AB/109/20/HH

White Cottage 32 King Street Arundel BN18 9BW

Rear single storey extension for new kitchen and living area, internal alterations, new and adjusted windows and doors, part replacement roof structure with 2 x conservation roof lights to the main building, re-covering of main roof and partial re-build of the detached garage with replacement pitched roof.

FURTHER COMMENTS ON AMENDED PLANS (25/01/21)

NORTHERN ELEVATION

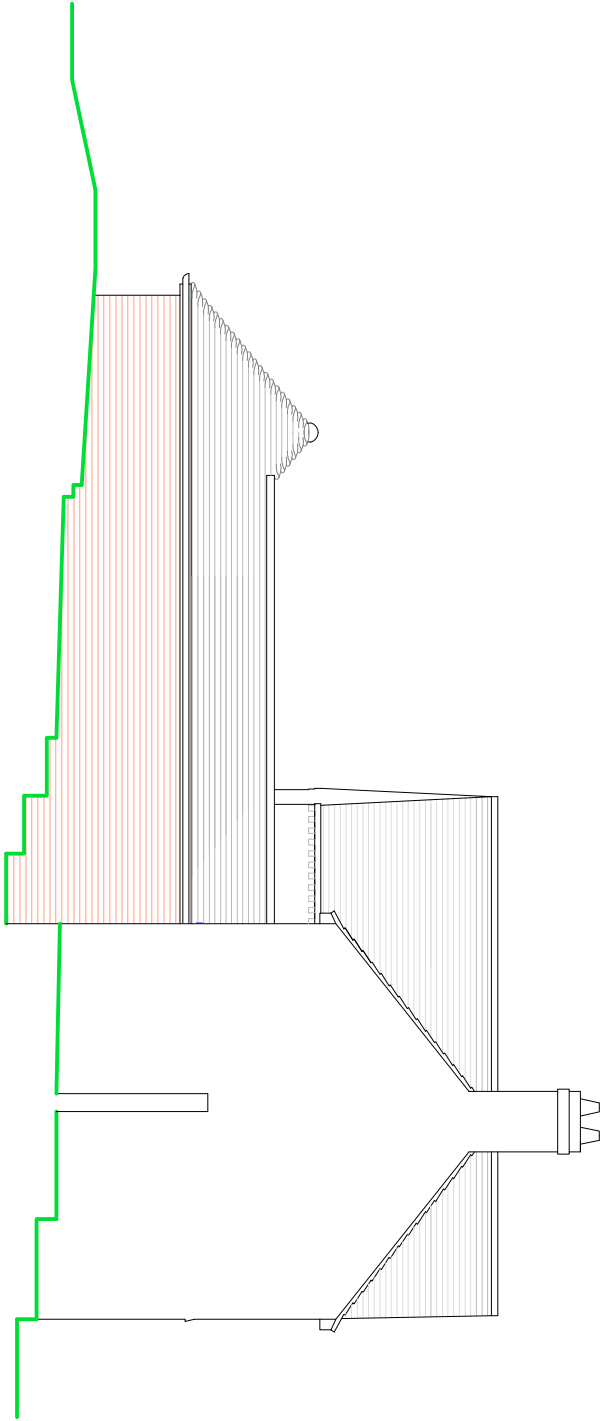
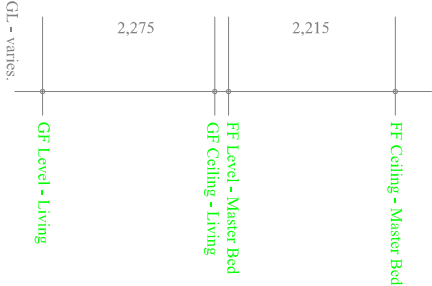
I note that the applicant has provided amended plans which relate to the proposed rear extension. The revised design has amended the northern elevation so that part of it steps away from the neighbouring listed building, whilst retaining more of the existing boundary hedge. The retention of more of the existing hedgerow is positive as it will help to screen the proposed extension from the neighbouring listed building. Further, I note the inclusion of new climbing plants to that part of the northern flank wall which is closest to the boundary, but would not benefit from being screened from the existing hedge. This would help to soften this part of the extension and is also considered to be acceptable.

If you are minded to approve the application, it is suggested that you request details of the proposed materials and planting on the northern elevation via a planning condition.
